From: Paul Cann <Paul.Cann@arun.gov.uk>
Sent: 03 February 2020 11:53
To: Planning.Responses <Planning.Responses@arun.gov.uk>
Subject: RE: Planning Consultation on: FG/148/19/HH

APPLICATION NO: FG/148/19/HH

Site Address: 14C Sark Gardens Ferring BN12 5QB

Description of Works: Creation of a second vehicular entrance to the property with a new bridge over the ditch an extended driveway and changes to hard and soft landscaping

PROPOSED BRIDGE.

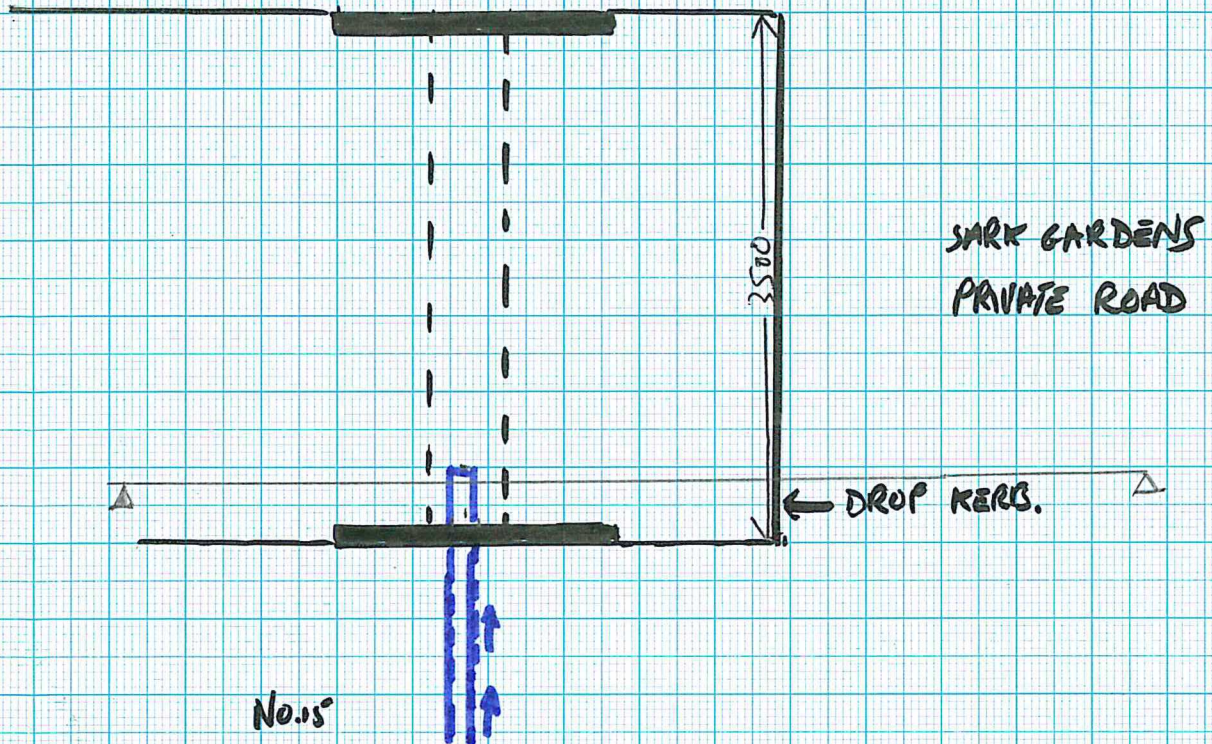
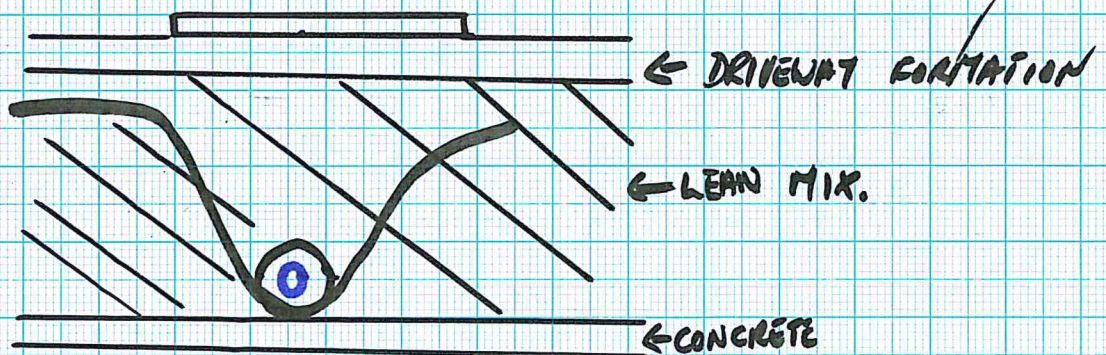
The proposal involves culverting (piping) a section of ordinary watercourse to facilitate a new vehicular crossing, for which land drainage consent will be required under the Land Drainage Act 1991. Please note that the drawings submitted are not of a sufficient standard/detail for this purpose.

It is likely that improvements to the existing ditch/existing culvert crossing (remove if not required?) will be required in order to ultimately accommodate the proposals.

Please apply standard condition PCENG3.
